Application No: WA/22/22/DOC
Site Address: Global Technologies Racing Ltd Arundel Road Fontwell BN18 0SB
Description of works: Approval of details reserved by condition imposed under WA/22/15/OUT relating to conditions 12-surface water drainage scheme and 20 d)-details of forecourt layout, drainage and lighting.

Thank you for your internet representation made on 14th April 2022 which has been recorded as an objection with the comments as follows:

The Planning & Environment Committee of Barnham and Eastergate Parish Council have considered the above application via an email exchange due to the fact that they do not meet again before the comments deadline. Through that exchange Committee Members agreed to submit an objection to the application as the proposed lighting scheme goes against the Barnham and Eastergate Neighbourhood Plan's policies:

Installation : Proposed Lighting

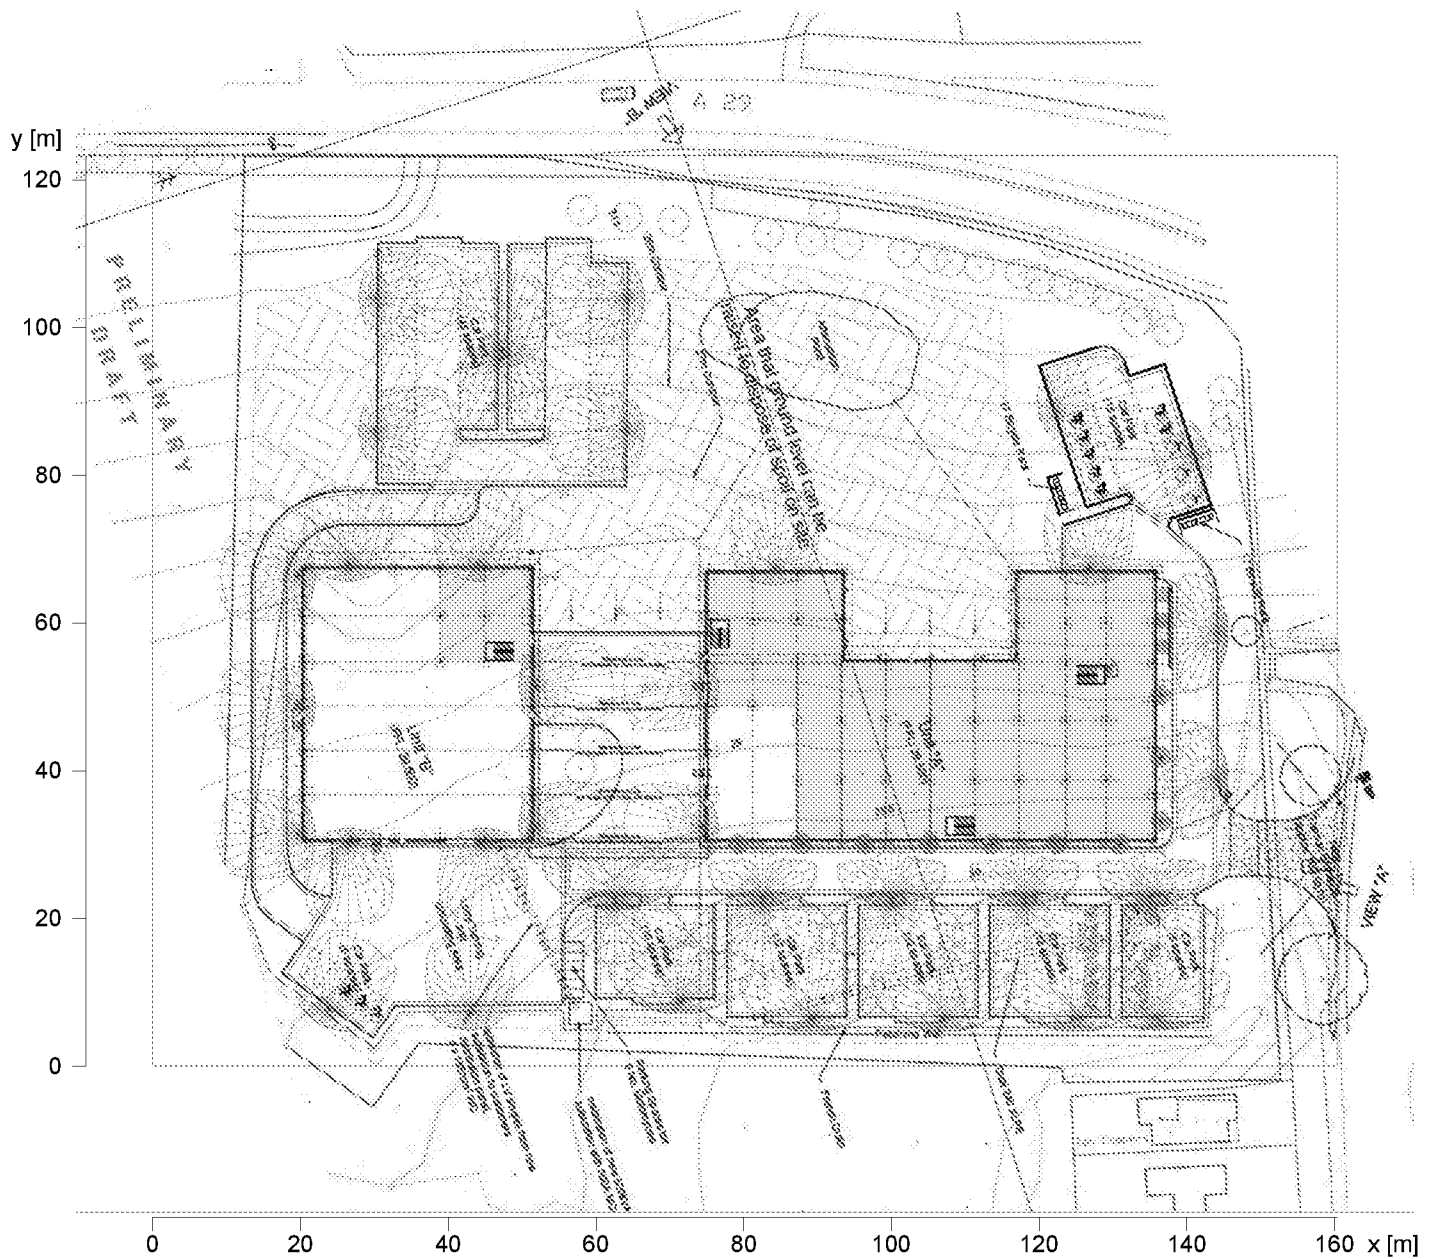
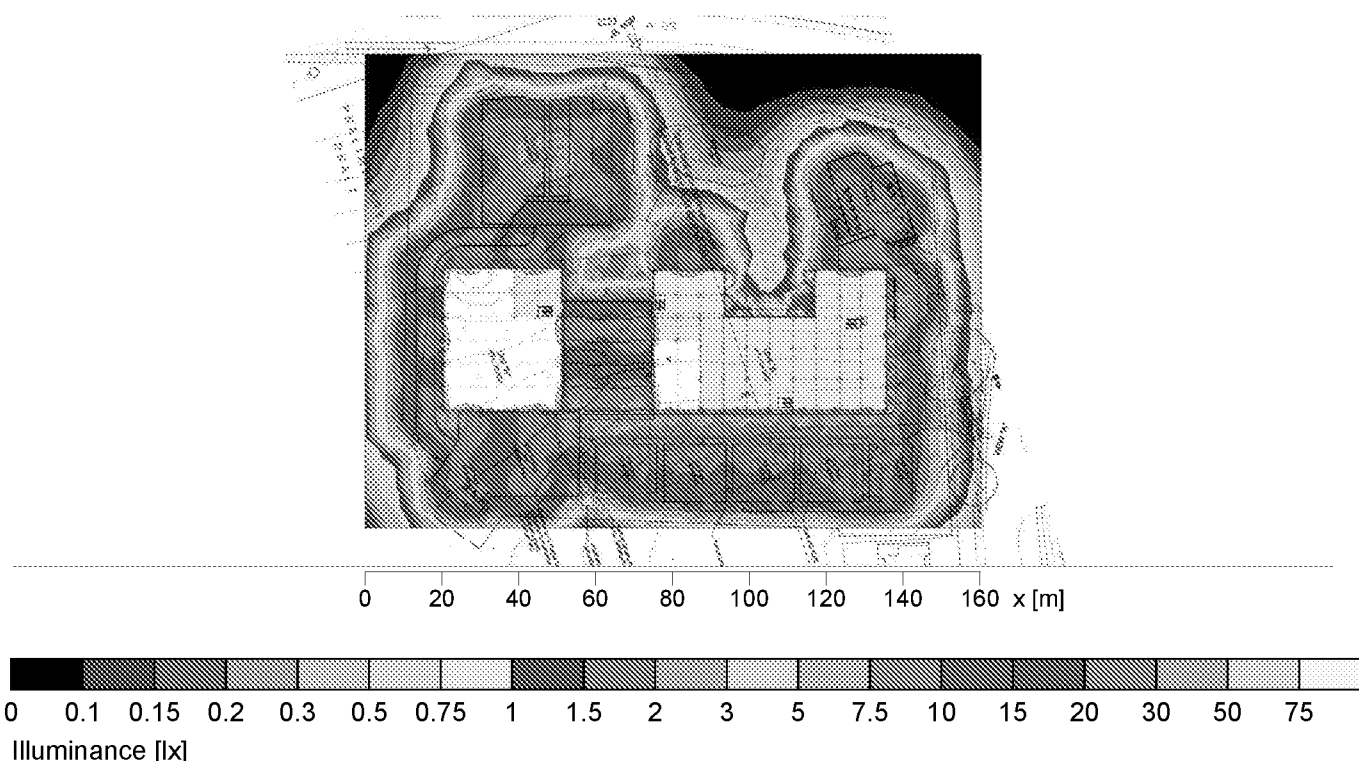
ES16 Dark night skies - New Development proposals which detract from the unlit environments of the Parish will not be supported. Development proposals should respect the unlit environment of the neighbourhood area and take all appropriate opportunities to reduce light pollution. New lighting will be required to conform to the highest standard of light pollution restrictions in force at the time. Security and other outside lighting on private and public premises will be restricted or regulated to be neighbourly in its use including floodlighting at equine establishments and on sports fields or sports grounds. Unless specifically requested by a statutory consultee, all new roads built as part of a new development will be encouraged to use motion sensitive street lighting.

We would ask that ADC in considering the application take careful consideration of this policy and assure themselves that the proposed lighting for this building will not have adverse impacts on the surrounding area which includes one of the biodiversity corridors also identified in the Made Barnham and Eastergate Neighbourhood Plan.
